**To the Planning Inspectorate.
Deadline 5 Written Representation 3 February 2021. (1 of 5)**

**PINS ref : EA1N 20024031. EA2: 20024032.
These remarks refer to both EA1N and EA2.**

To the Planning Inspectorate.
Deadline 5 Written Representation(2 of 5).
PINS ref: EA1N: 20024031 EA2: 20024032.
These remarks are in respect of both EA1N and EA2.

To the Planning Inspectorate.
Deadline 5 Written Representation , 3 of 5
PINS Ref: EA1N: 20024031 EA2: 20024032.

| | Rev | Date | By | Comment | Approved: | AH | | | APFP Ref: 5(2) (o) | | Doc ref: 2.10 |

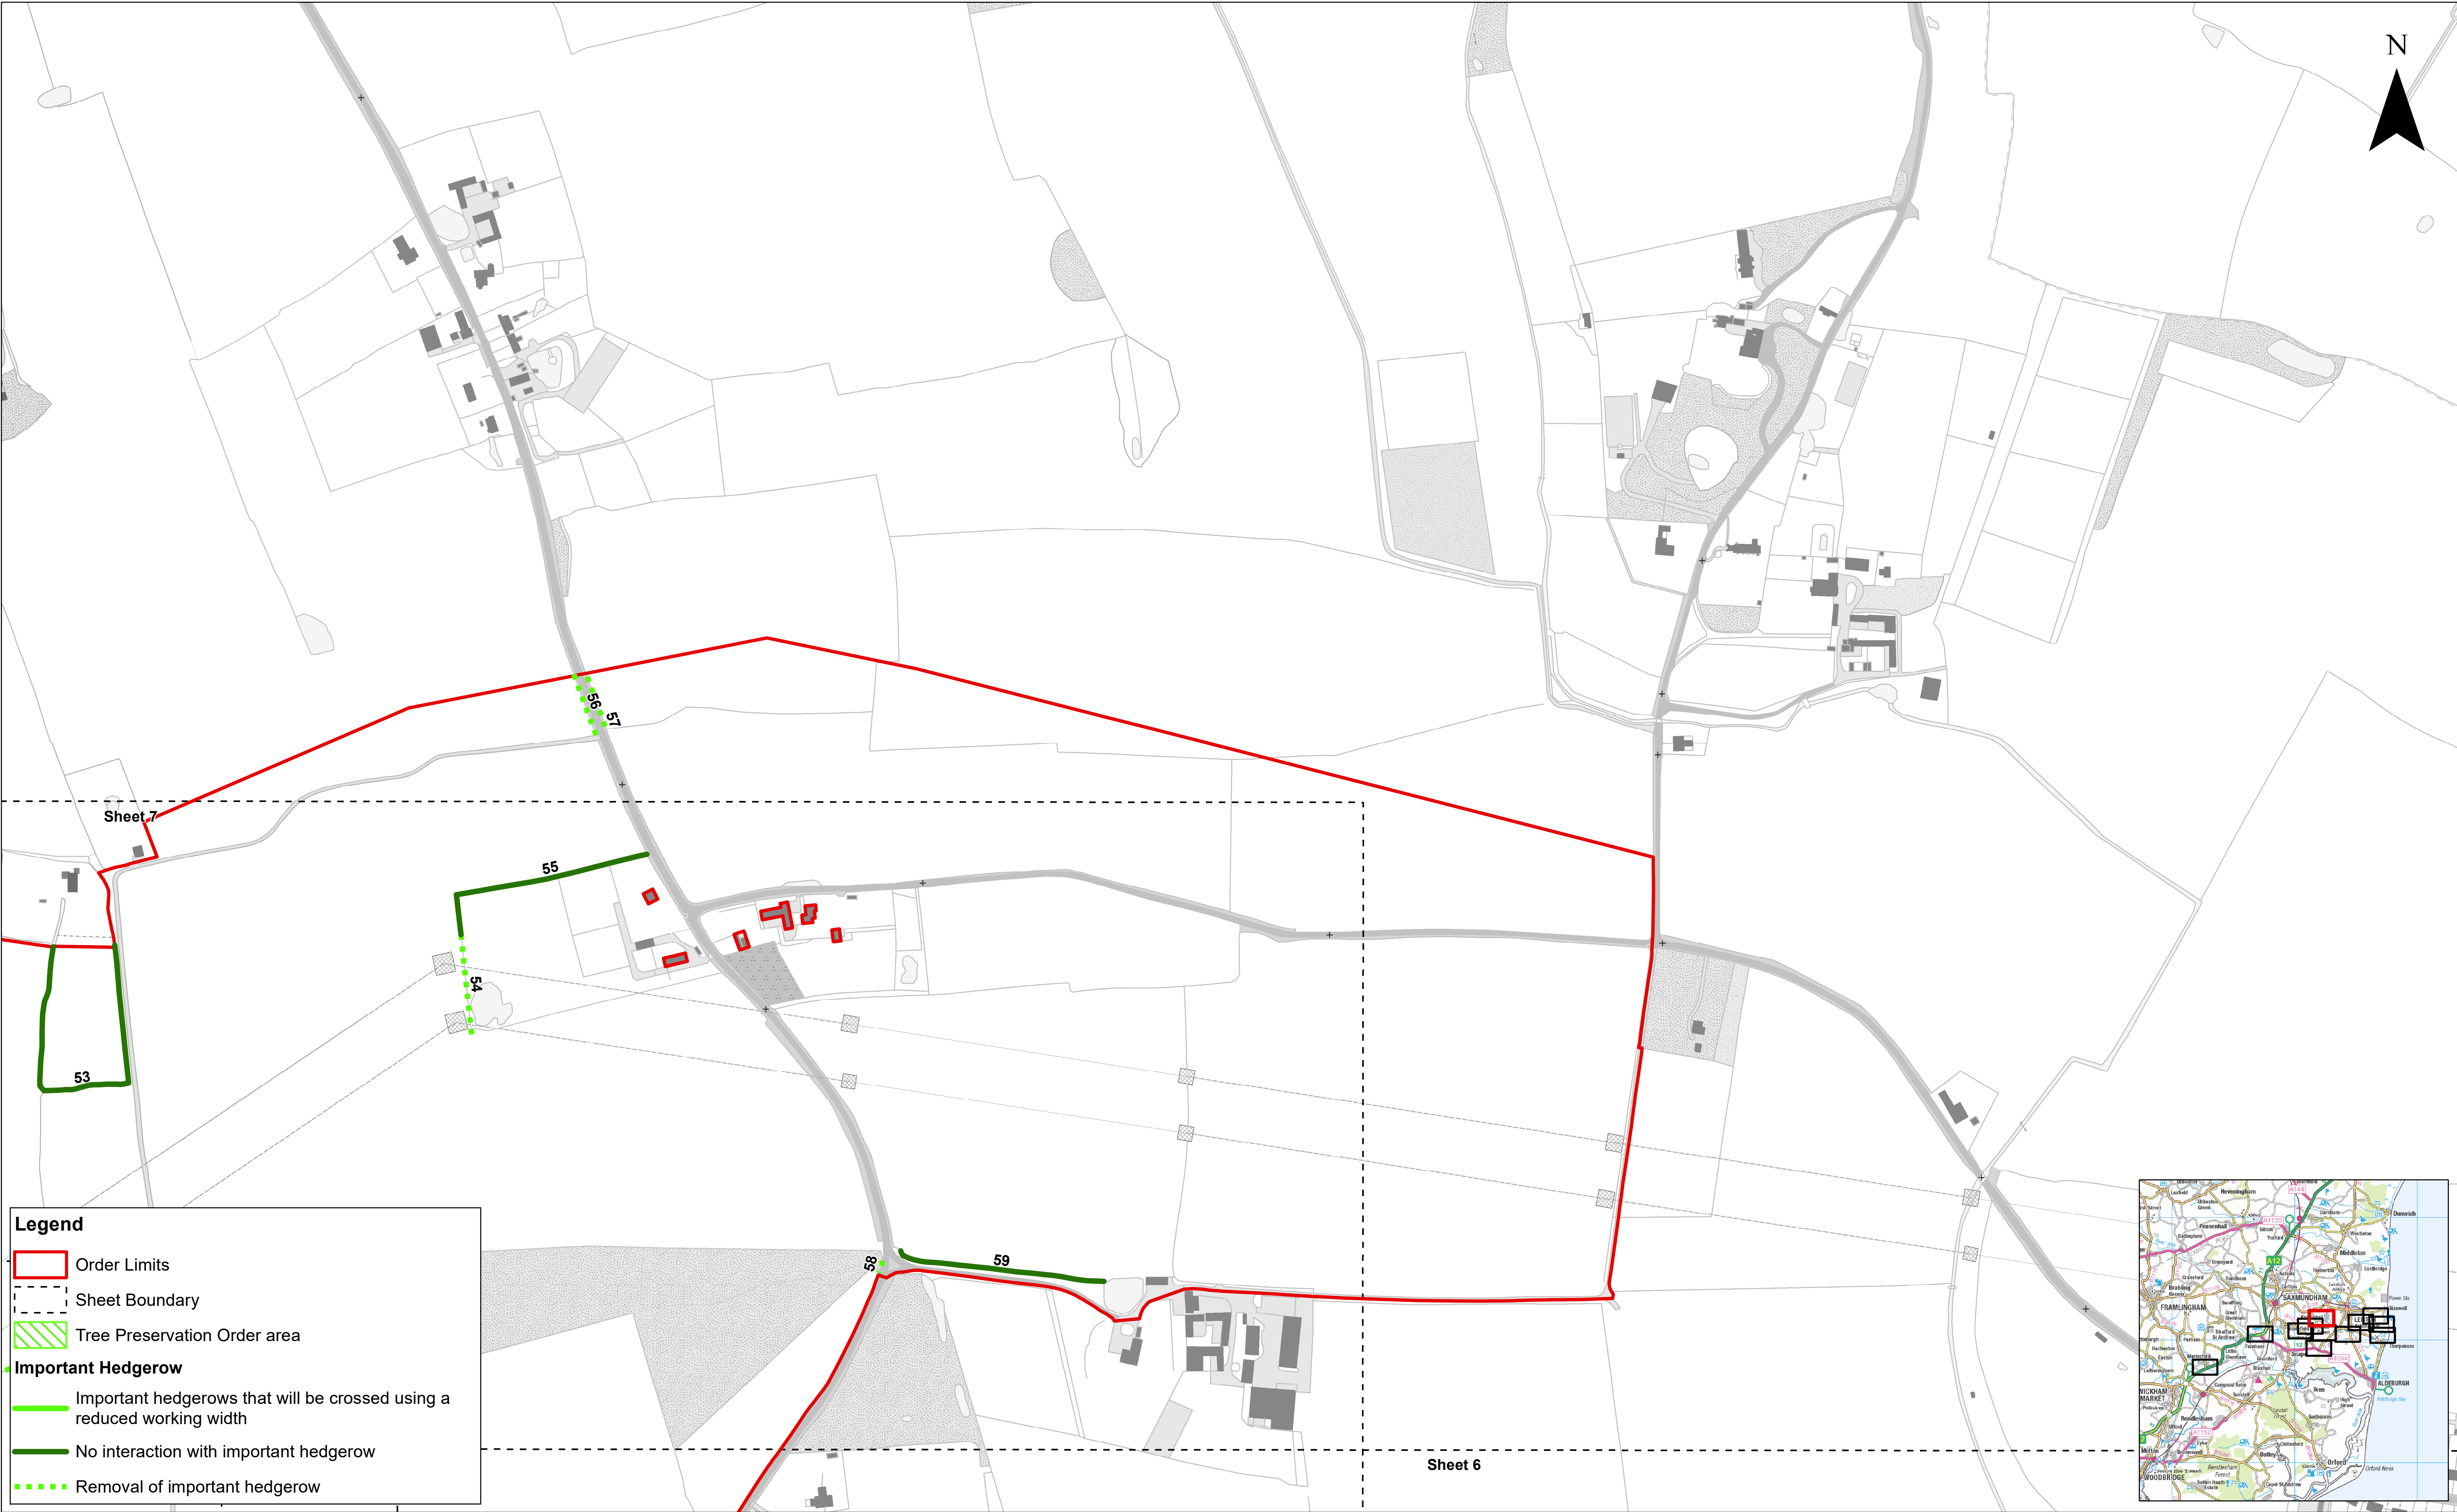
Hedgerow 3, on Sheet 2 will have been walked along by the Panel at their site visit on 27 January, as they walked southwards with the sea and Plot 4 at their left hand side towards Thorpeness Common. In fact it consists largely of very large shrubs and many trees, rather than being recognisable as a hedgerow, on the side adjoining Work 8, and there are also trees and shrubs on the seaward side. I would suggest that these should be identified as two hedgerows, as presumably both will be removed, rather than one. I attach a screenshot of the map **NRMM Emissions Assessment Scenario A, Sheet 1** to identify the location of these hedgerow(s) in relation to the Landfall HDD construction site. The line of growth of Hedgerow 3 is highlighted in green

.....
The destruction of these long established and densely populated hedgerows will not only

cause ecological damage, but will also remove a significant stabilising buffer between Work no. 8 (the Landfall HDD compound) and the dwellings at [REDACTED] and Warden's.

These plantings and vegetation prevent sand storms, and their removal will produce a very large tract of land subject to erosion and the loss of an important . It would also remove some noise and pollution mitigation for the residents near [REDACTED] and Warden's. The hedgerows will take many years to re- establish, if ever, to the same state. Much reference has been made throughout this Examination to the difficulty of growing trees and the very long time periods involved in this local area, particularly here where the ground is mainly sand.

Hedgerow 4 on the same map, **Sheet 2, (APP-020)** adjoins a point on the access to Warden's(an access which may or may not remain usable by us, depending upon the success of the Applicants negotiations with the neighbouring landowner. I refer to this in more detail in my Deadline 5 submission, Socio- Economic effects). This vegetation also forms an important wind and dust break, as well as being a valuable refuge for deer as they approach the salty vegetation nearer the sea and a rich habitat for wildlife.

If these important hedgerows are to be removed, I would like to see the severance of hedgerows limited at these locations according to the Applicants own undertaking. (Statement of Common Ground with East Suffolk Council and Suffolk County Council LA 02.24).
